20260728-ACP-324277

Ref: 324277

For: Application for Substitute Consent pursuant of Section 177E of the Planning and Development Act 2000 (as amended) consisting of the quarrying of rock that took place between February 1990 and October 2014, along with all associated site development works. The application is accompanied by a remedial Environmental Impact Assessment Report (rEIAR) and a remedial Natura Impact Statement (rNIS)

Site: Ardcahan, (townland), Dunmanway, Co. Cork.

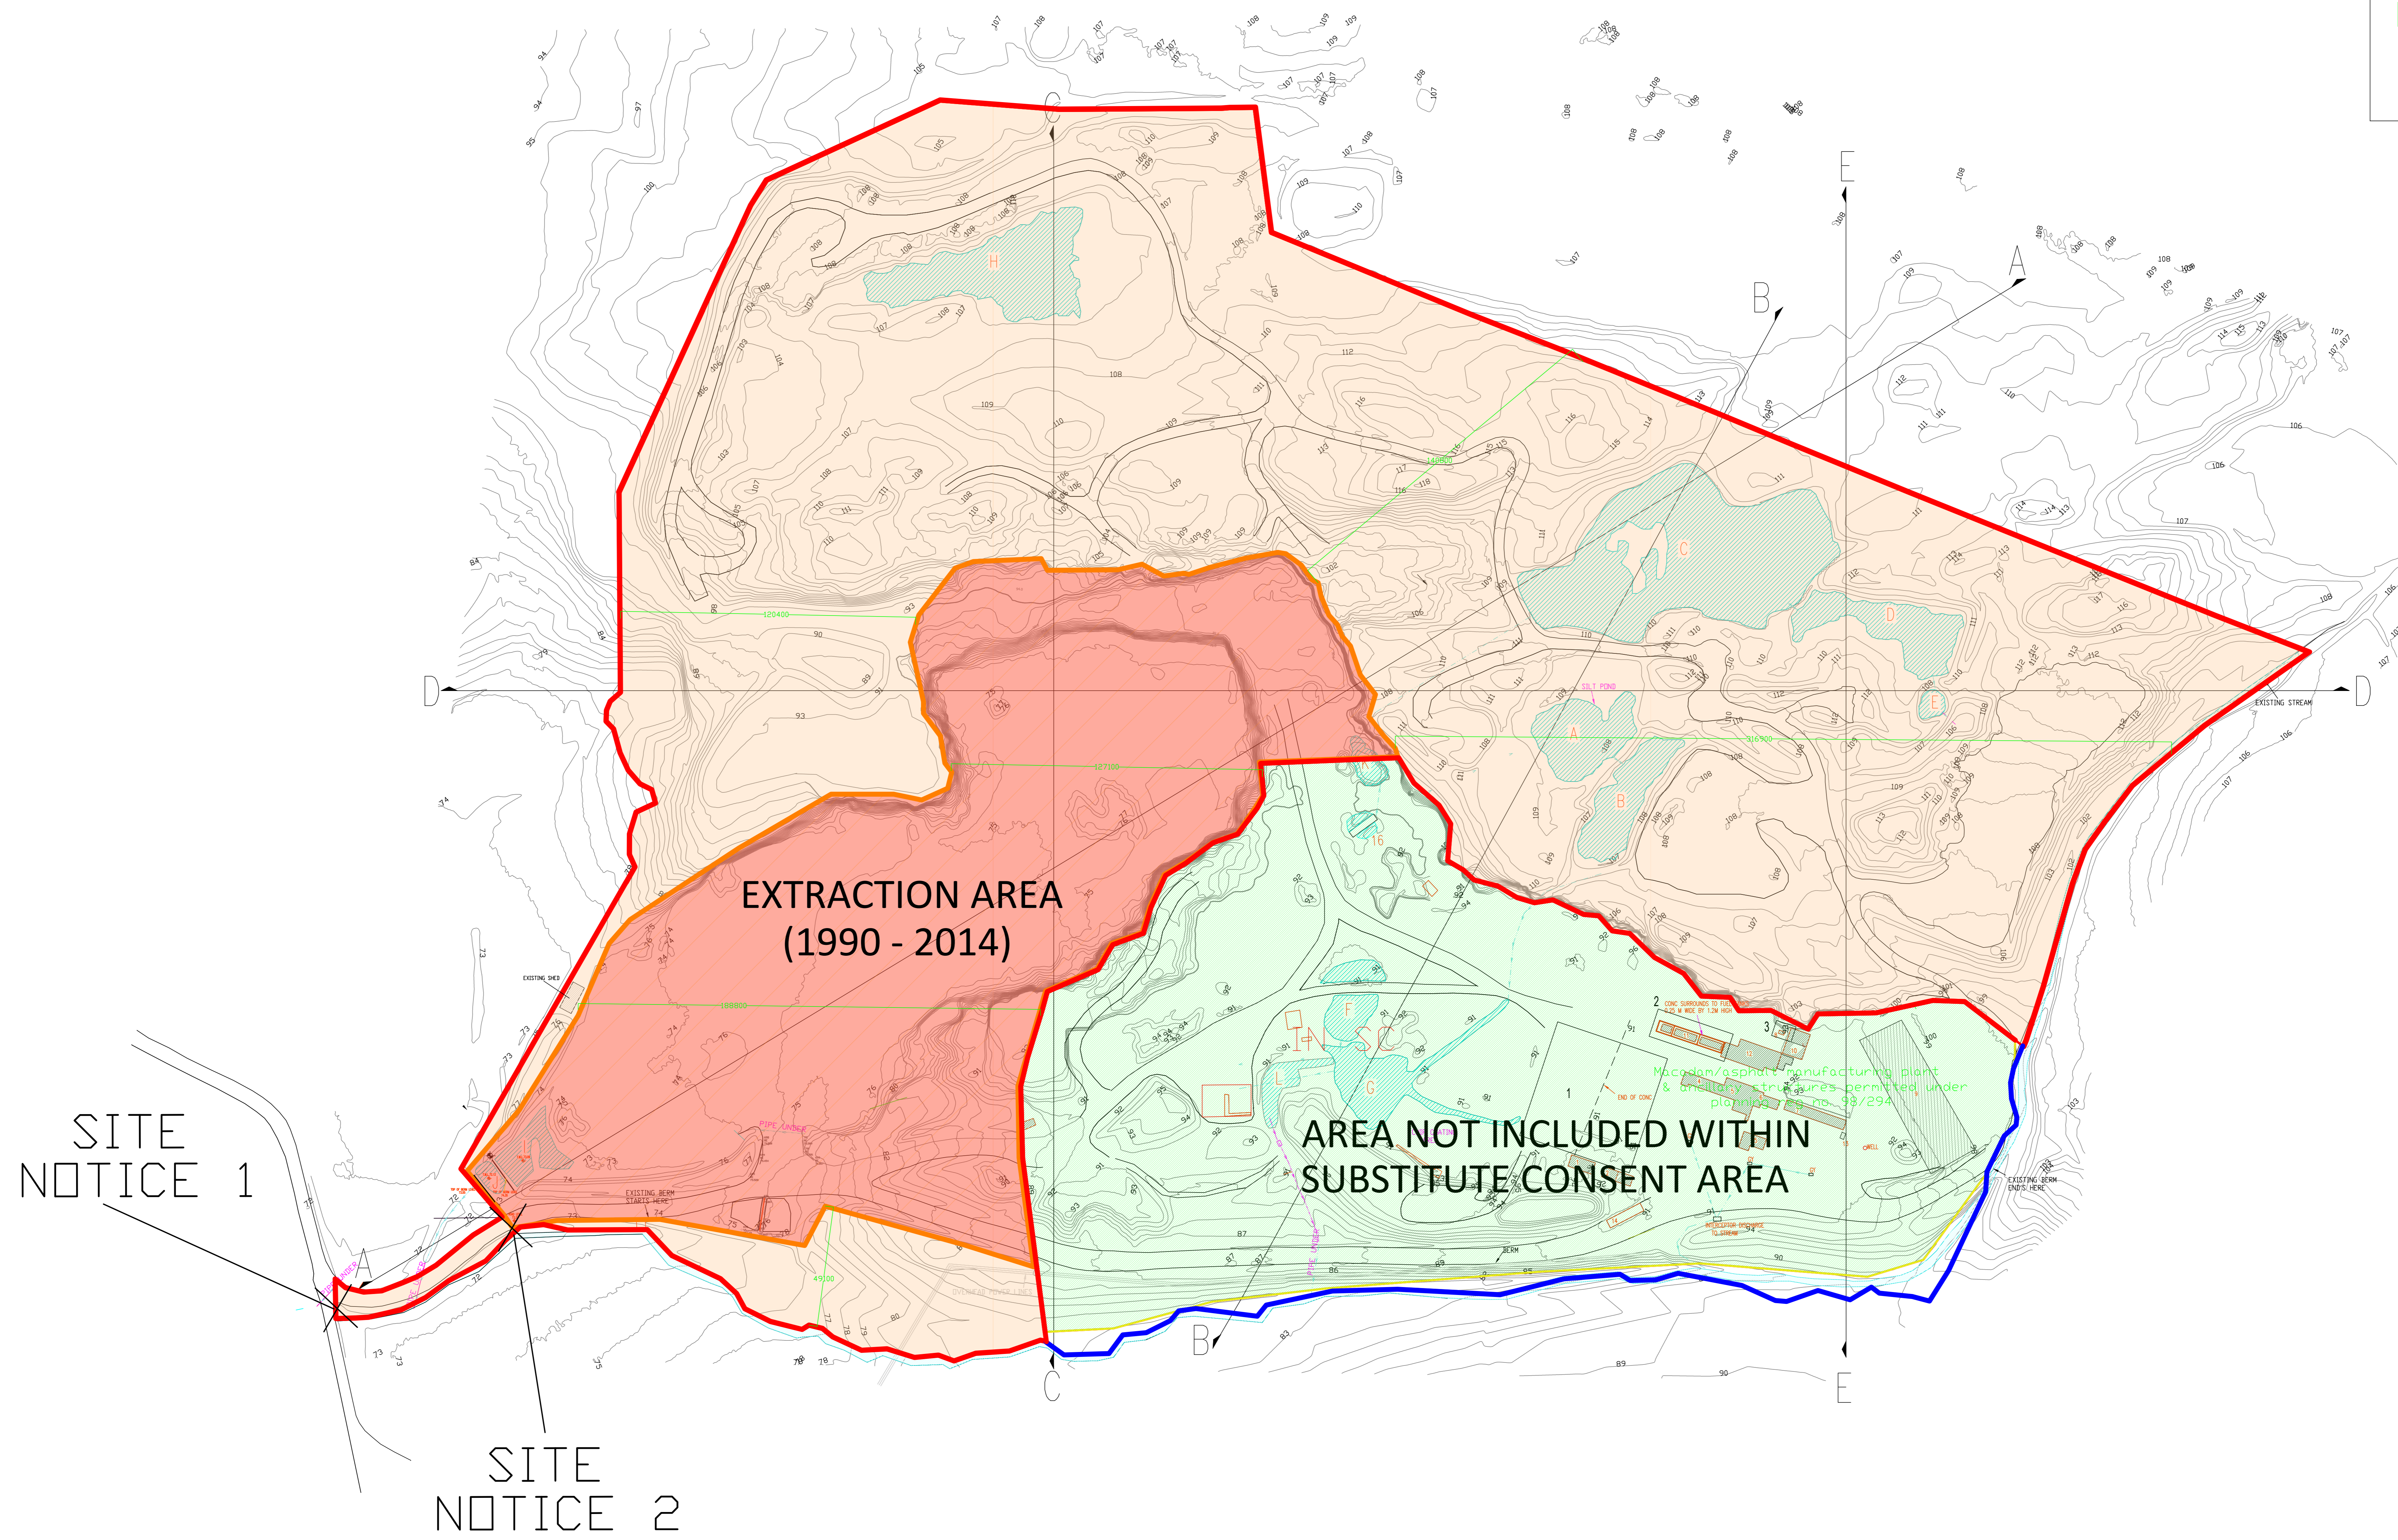
- the drainage/settlement ponds (such as ponds F,G,L) had negligible effects on water quality;
- blasting effects would have been damped by water browsers or intercepted by settlement ponds (are there records confirming the use of such mitigation?);
- hydrocarbon spills would not have occurred or would not have a water quality impact (are there records confirming the use of bunds for fuels, use of designated areas for refuelling?).
